Boston Alternative Energy Facility

Fifth Report on Outstanding Submissions

Planning Inspectorate
Reference: EN010095

Document Reference: 9.99

Figure 3-1 Possible Locations of compensation options

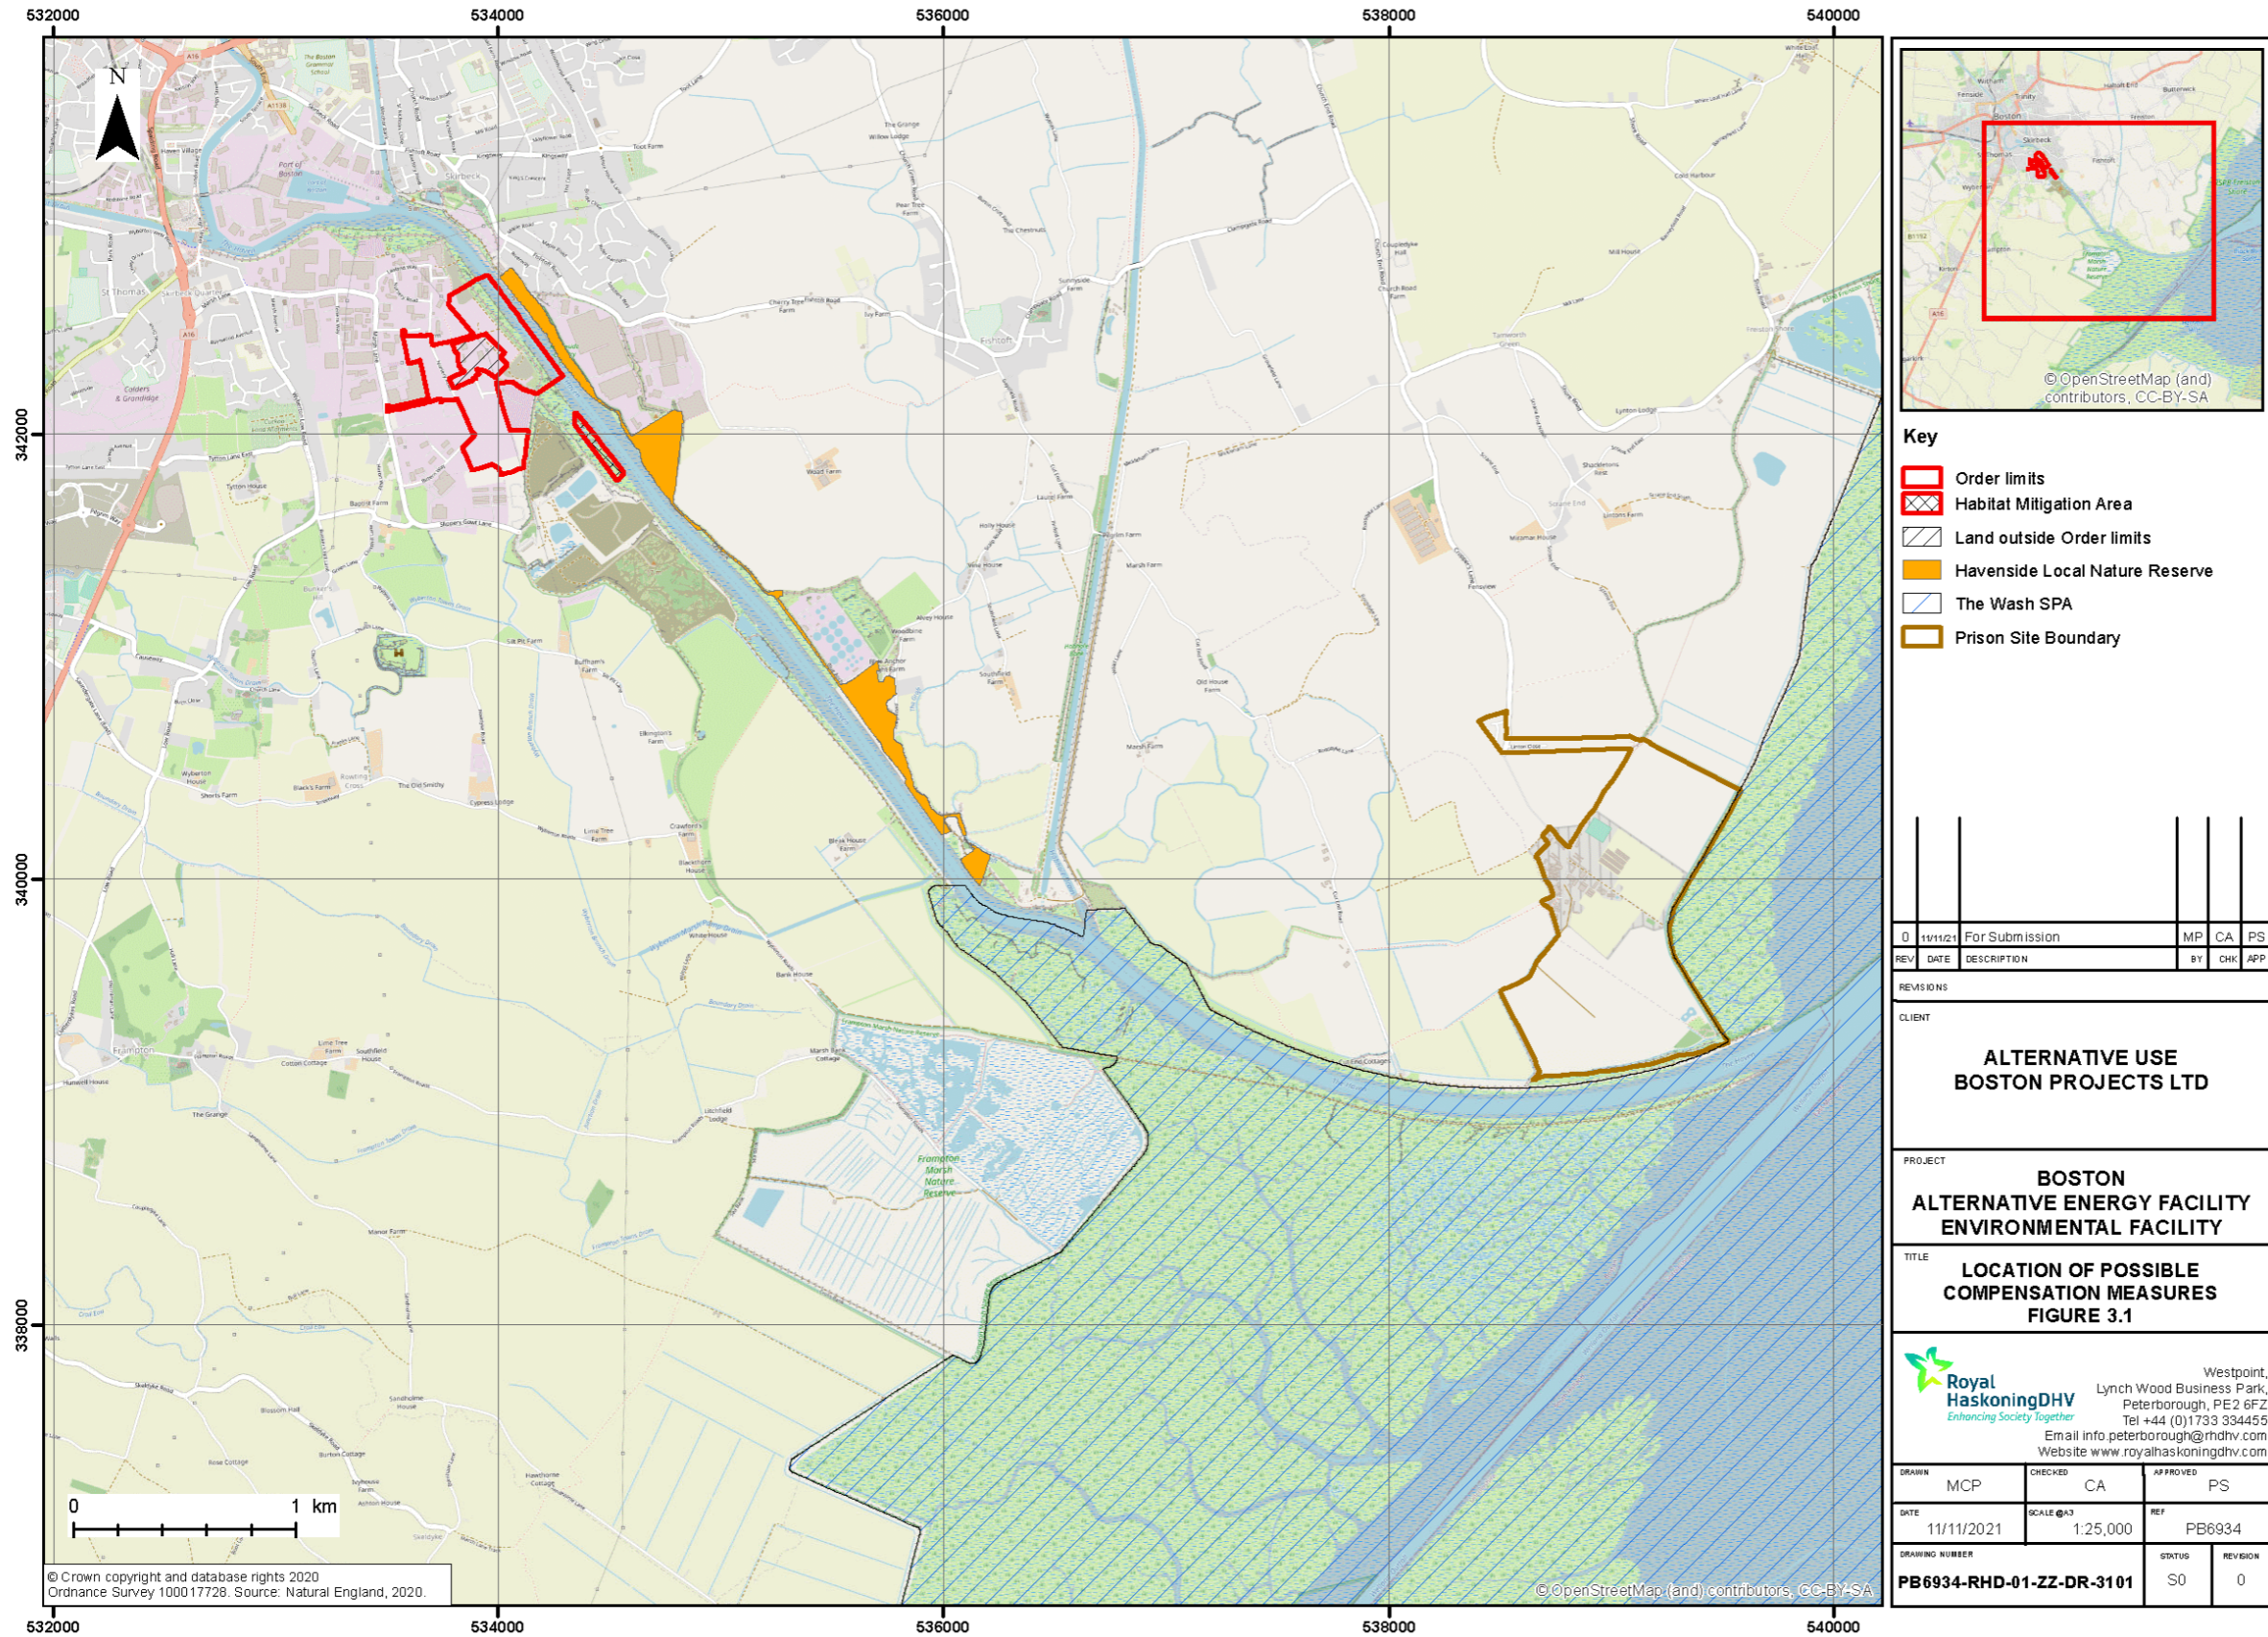
32	21. Table 3.1. Option 4-6. NE notes that the options with most potential to compensate for impacts on the SPA are now discounted
